WEST SUSSEX COUNTY COUNCIL CONSULTATION

TO:	Arun District Council FAO: Maria Tomalova
FROM:	WSCC - Highways Authority
DATE:	6 August 2020
LOCATION:	Swallowfield, Eastergate Lane, Eastergate, PO20 3SJ
SUBJECT:	BN/81/20/DOC Approval of details reserved by condition imposed under ref BN/121/19/PL relating to Condition Nos 3 - surface water drainage, 4 - Construction Management Plan, 5 - materials & finishes, 6 - hard & soft landscaping, 7 - drainage scheme, 8 - storage of waste and 13 - renewable energy.
DATE OF SITE VISIT:	N/A
RECOMMENDATION:	Advice
S106 CONTRIBUTION TOTAL:	N/A

title
Proposed Construction Management Plan

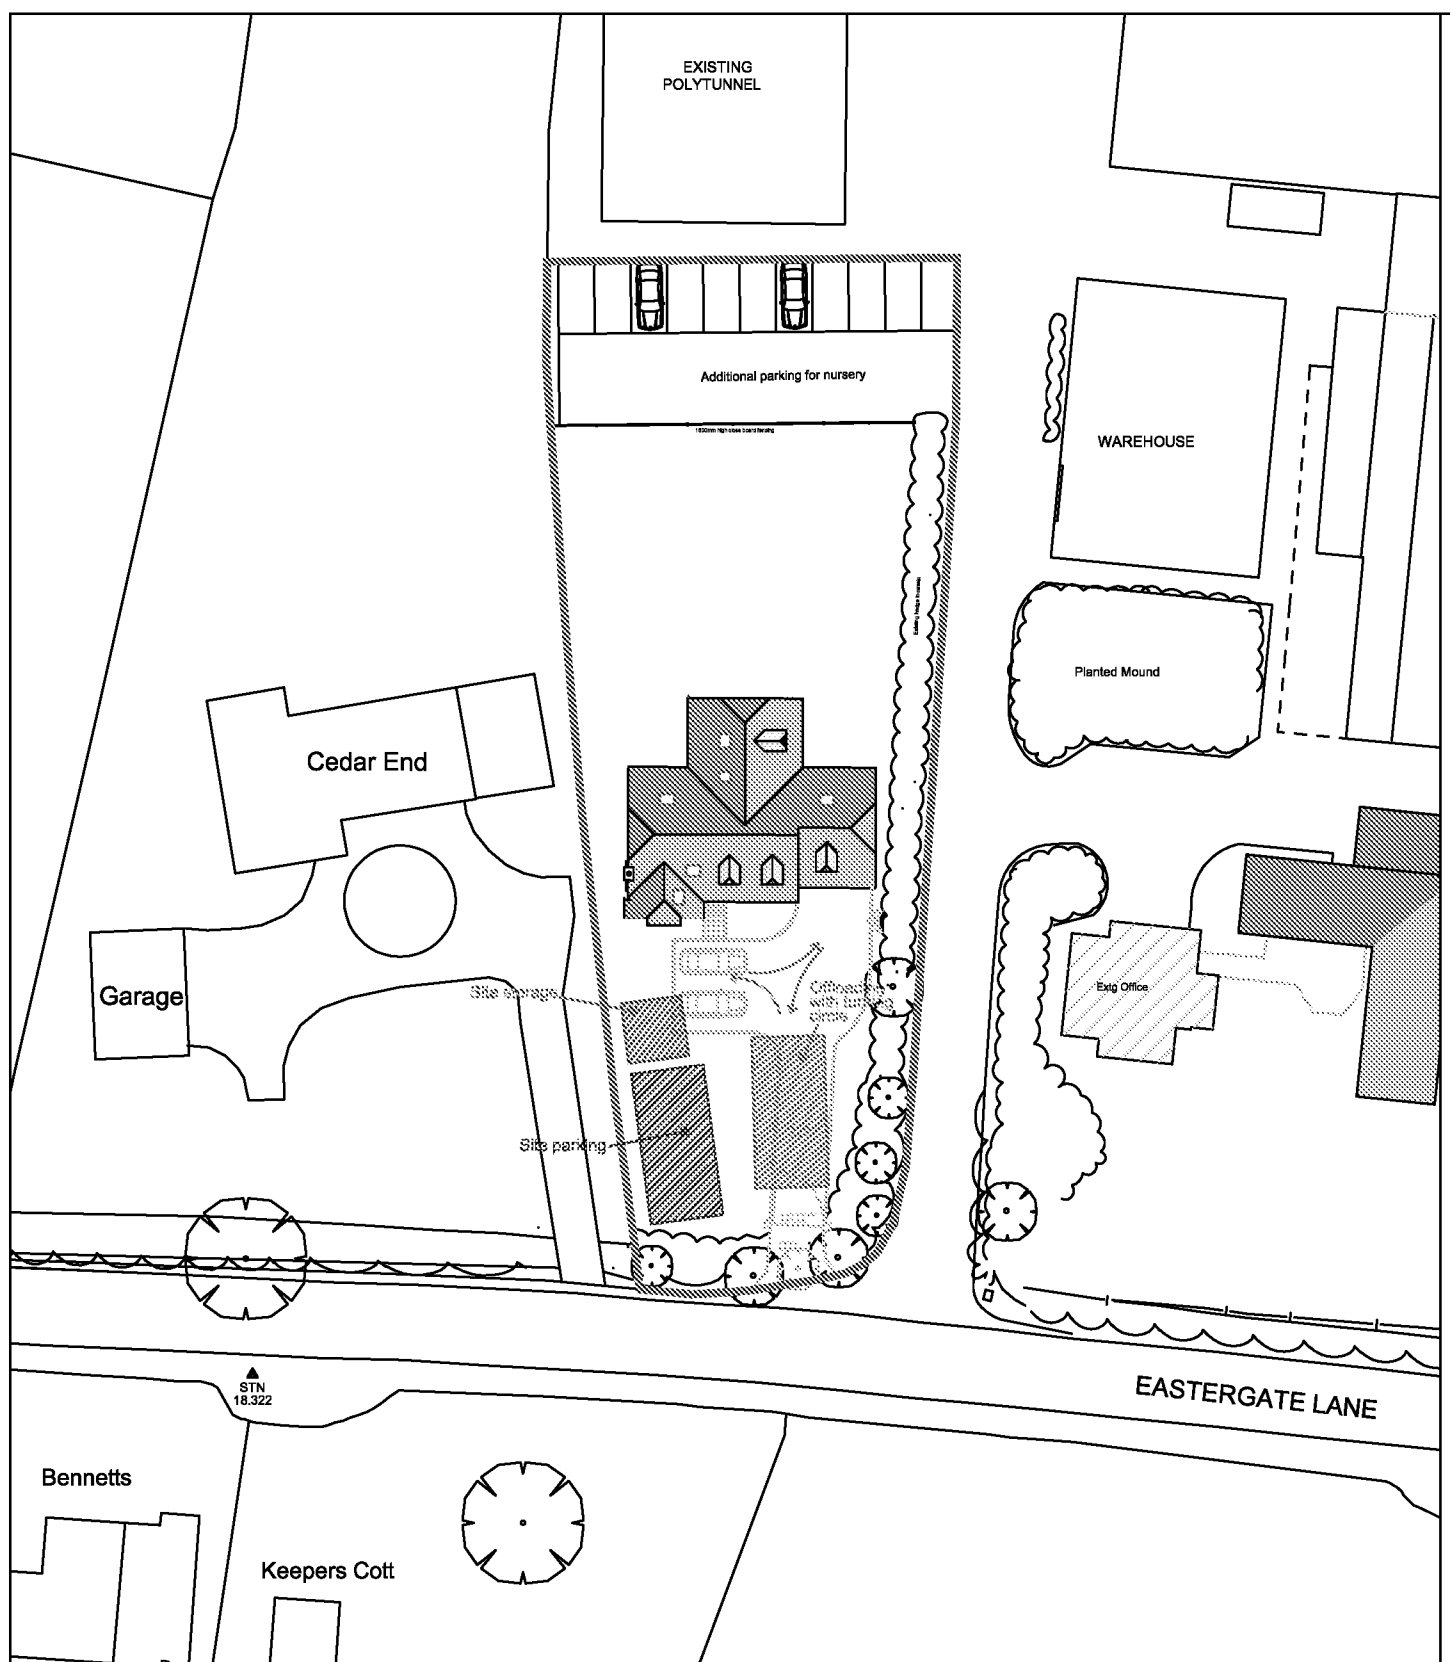
The applicant has submitted a Construction Management Plan (CMP), outlining the above mentioned requirements. This is supported by a site plan. Having reviewed the CMP and Site plan, the LHA is satisfied that Condition 4 can be discharged, subject to the below comments.

E – A designated area for contractor parking on-site has been demonstrated on the site plan.

F – A designated area for loading and unloading on-site has been demonstrated on the site plan.

G – A designated area for storage of plant and materials on-site has been demonstrated on the site plan.
